Application No: Y/53/22/DOC
Registered: 29th April 2022
Site Address: Land at Stakers Farm North End Road Yapton
Description of Works: Approval of details reserved by condition imposed under Y/44/17/OUT relating to condition 17-as built drawings of implemented scheme.

Following your comments on my email the other day, please find below the response for: Y_53_22_DOC

The construction does not appear to have been carried out in accordance with the design, in addition there are still elements of the construction which are wholly reliant on the contractor's information rather than an independent verifier. As a result, **we would not recommend Discharge of Conditions** until the following information has been provided and following points have been addressed and approved in full.

OUTLOOK

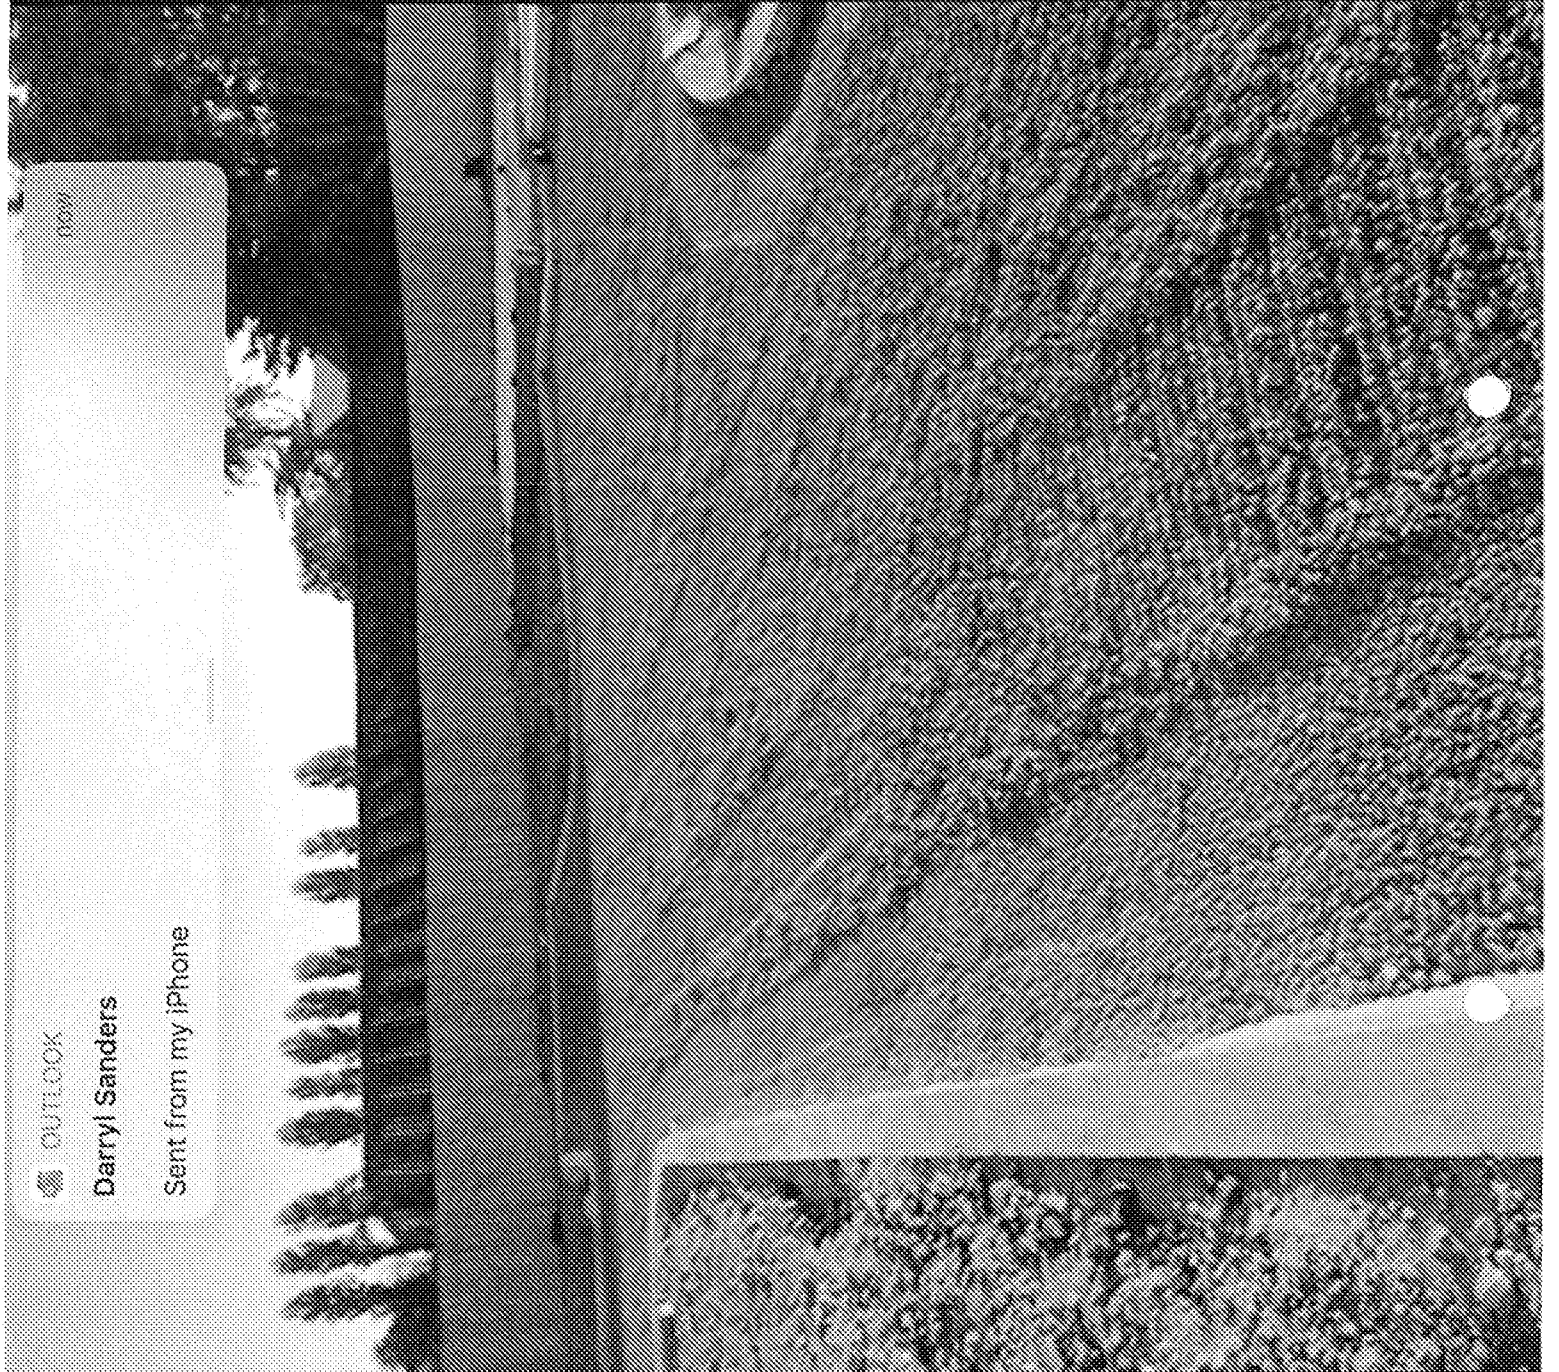
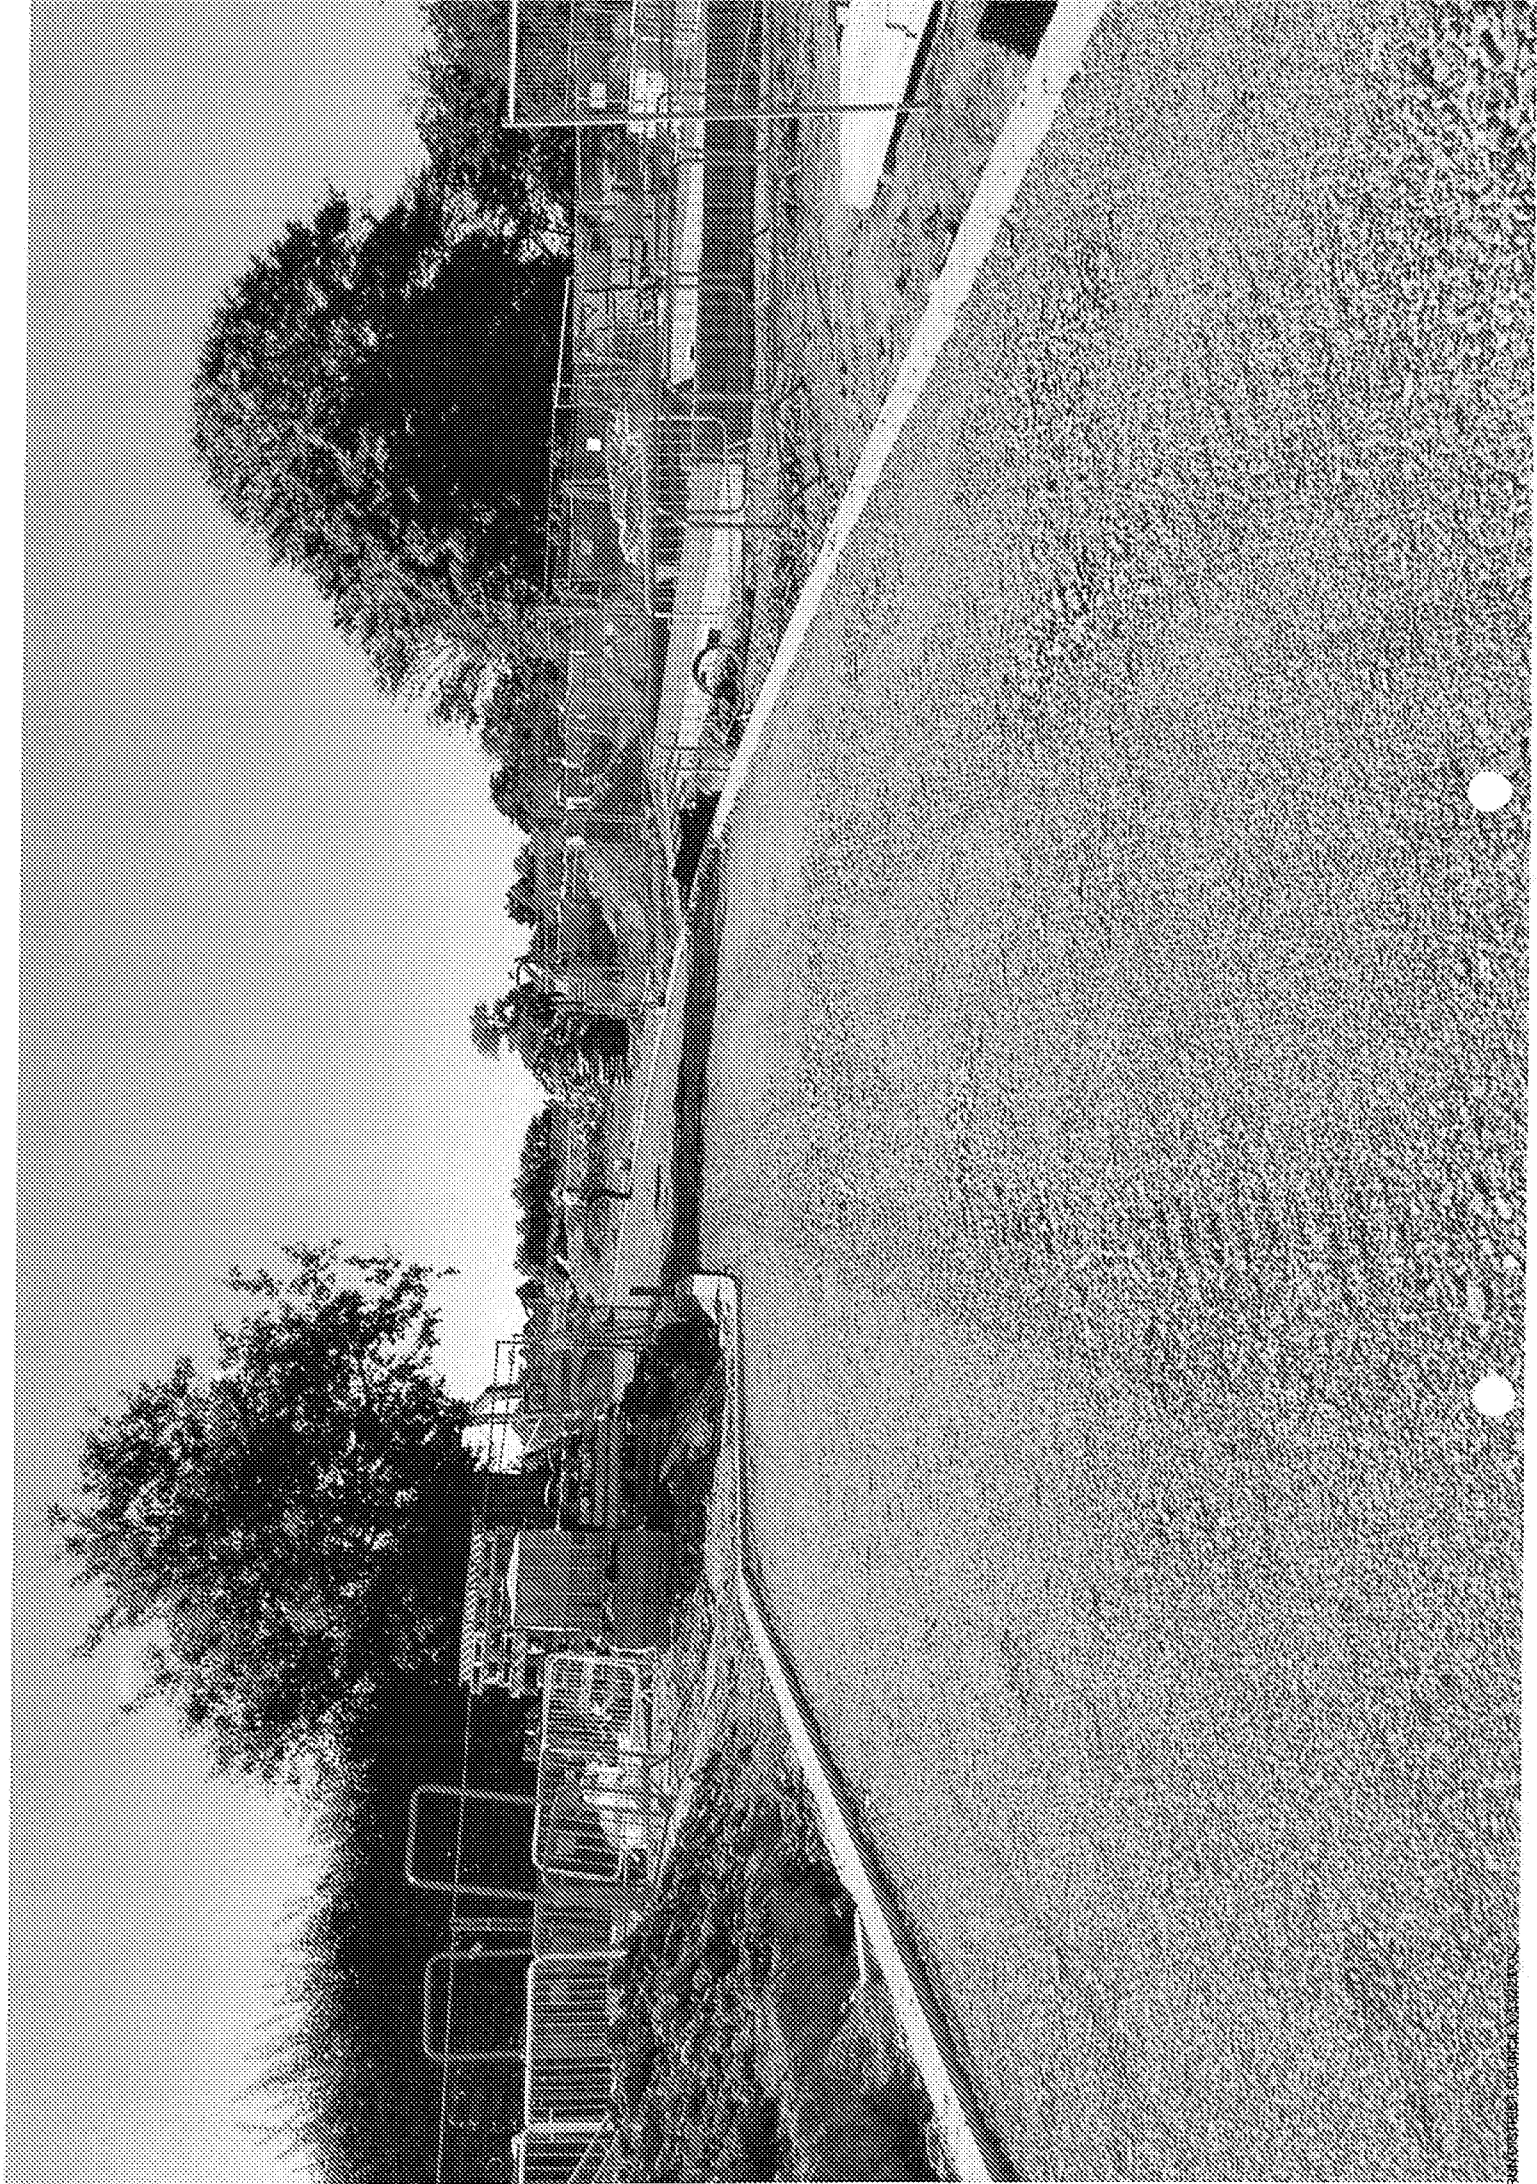
- 3) Some of the installation seen in photographs provided as part of the application does not appear to match the design drawings, and in some cases contains clear issues that need remediating or checking (as part of point 2). These include but are not limited to:

- Checking the membrane and gravel surround to some of the soakaways / infiltration blankets to ensure there is a membrane between the crates and gravel surround. This appears not to be the case in one of the photographs although it is unclear if this was simply a photograph showing the system prior to or post of the membrane being laid. Checking this was installed correctly and as designed will be essential.

- Checking and remediation of the poorly constructed sediment traps (assuming they are installed as photographed). The sediment traps should be installed as per the submitted drawings. These photographs show several defects in construction including square cut outs used to house round pipes, cracked rims and

plastic, the use of unapproved materials within their construction, rubble filling the base (which visually cannot be confirmed to have been lined) and concrete which appears to have been used as a sealant and is partially blocking one pipe outlet. None of this appears on any of the approved drawings.

- A proposal for remediating these issues should be submitted.
- 4) The letter submitted detailing all of the drawings refers to YAP-180-31 REV C4 however, the submitted planning drawing is Revision C5. The applicant will need to confirm which drawing the contractor was working off and confirm that the scheme was not constructed to an earlier design.
- 5) We also acknowledge significant differences in the levels for the base of the permeable surfacing, and appreciate the revised calculations showing that this will only result in minor flooding in one area of the site. This is noted to occur but is not significant enough to warrant remediation as the volumes are small and flooding only occurs infrequently (based on the model results).
